DXF Electronic Approval Form

DRB Project Case #: 1004791

Subdivision Name: GREVEY--TRACT C1A

DRB Comments

N.T.S.
 ZONE ATLAS:
 J-20-Z
 Vicinity Map

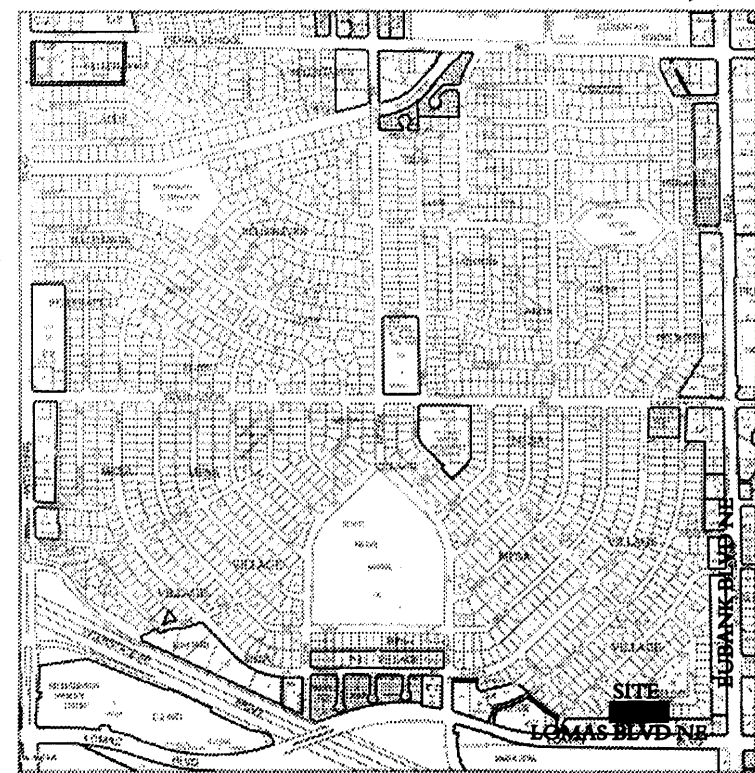
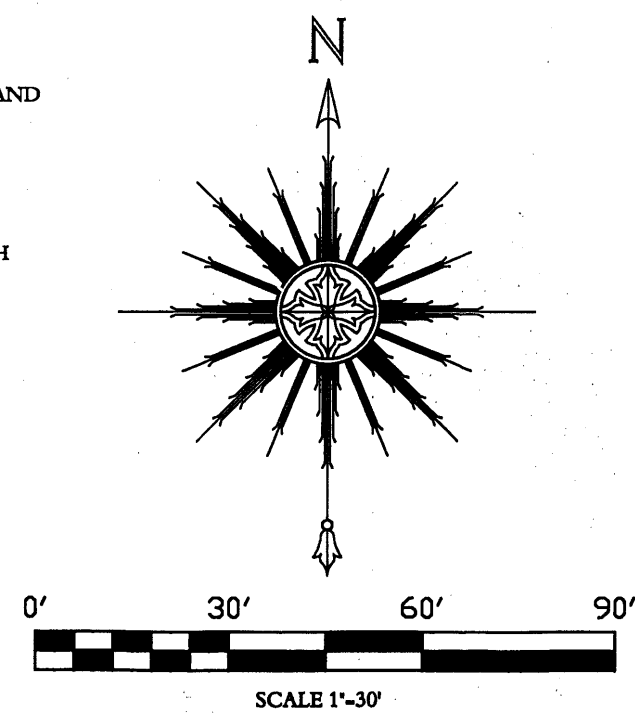
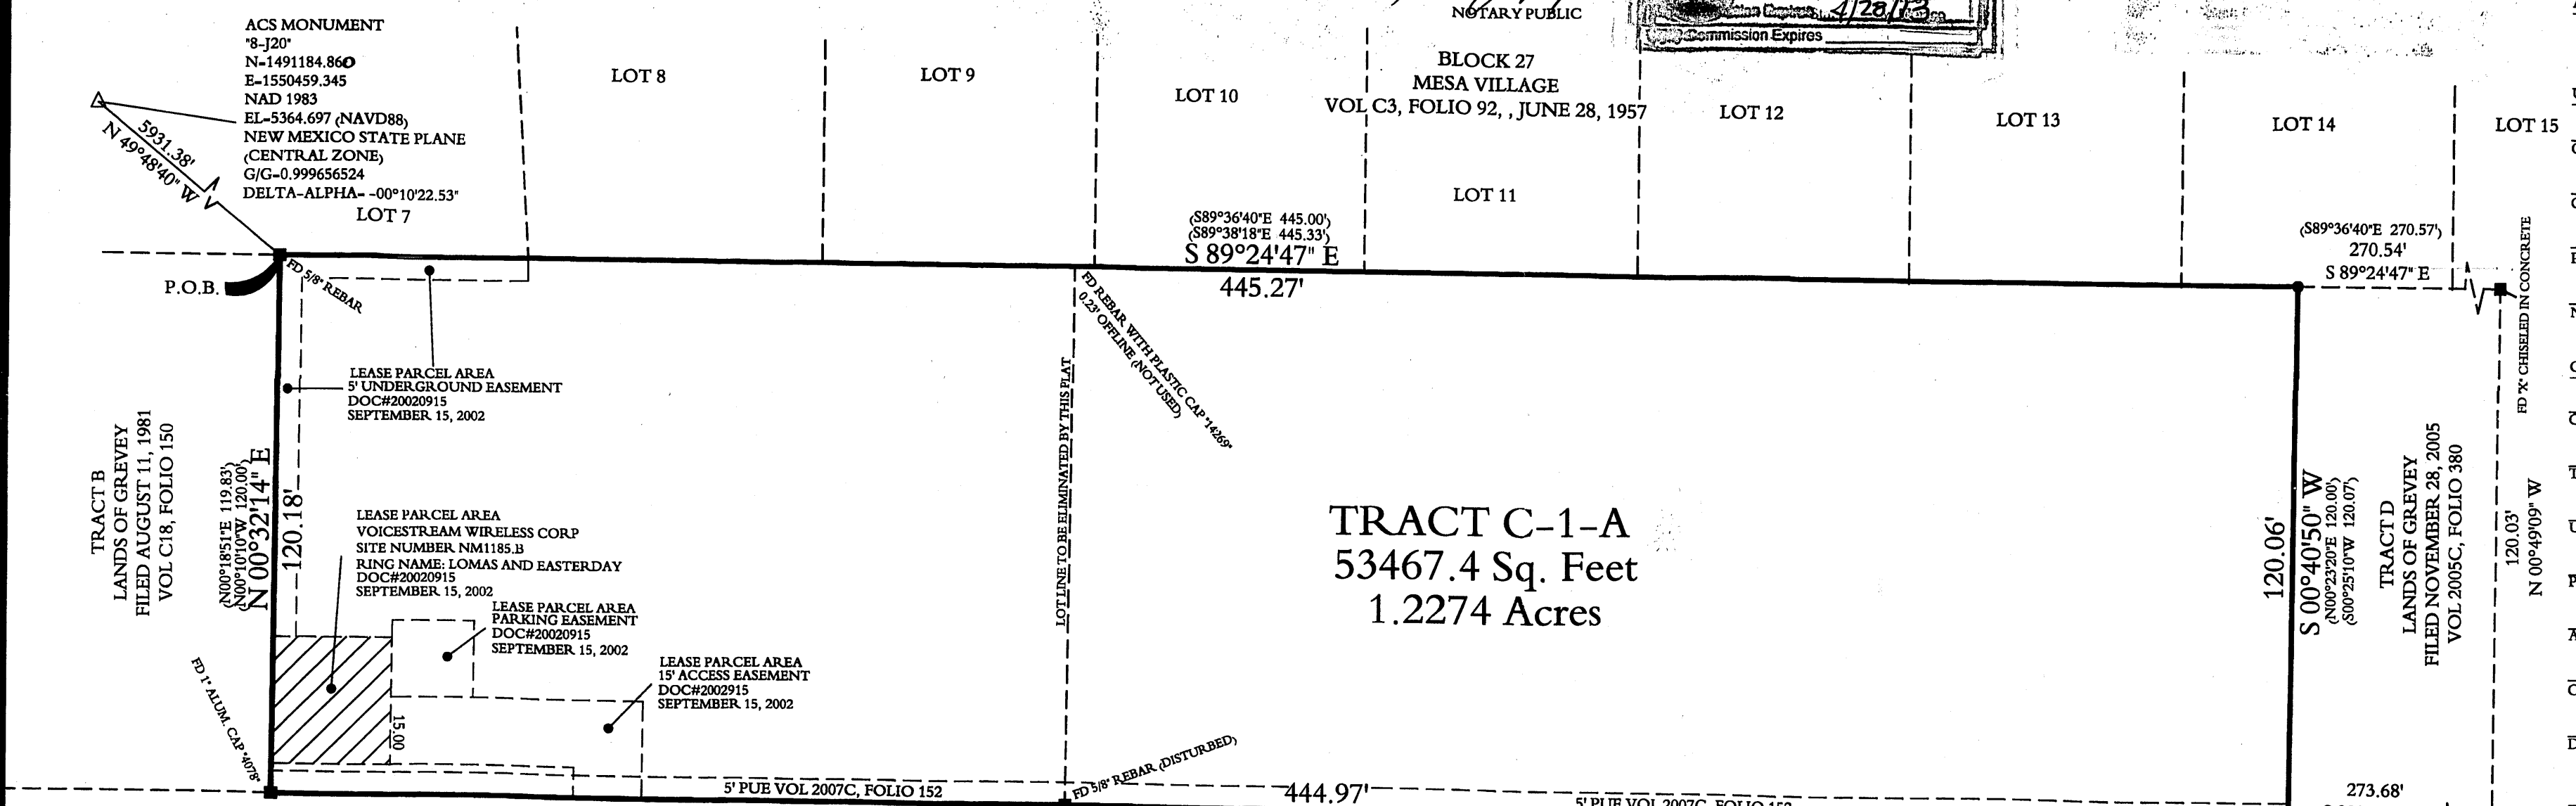
A Solar Note consistent with § 14-14-4-7 of the Subdivision Ordinance is required, specific to this type of request, i.e. use the words "THIS PLAT" (rather than the words "REQUESTED FINAL ACTION") at the beginning of the note, and do not use the words "OR SITE DEVELOPMENT PLAN FOR SUBDIVISION" at the end of the note.
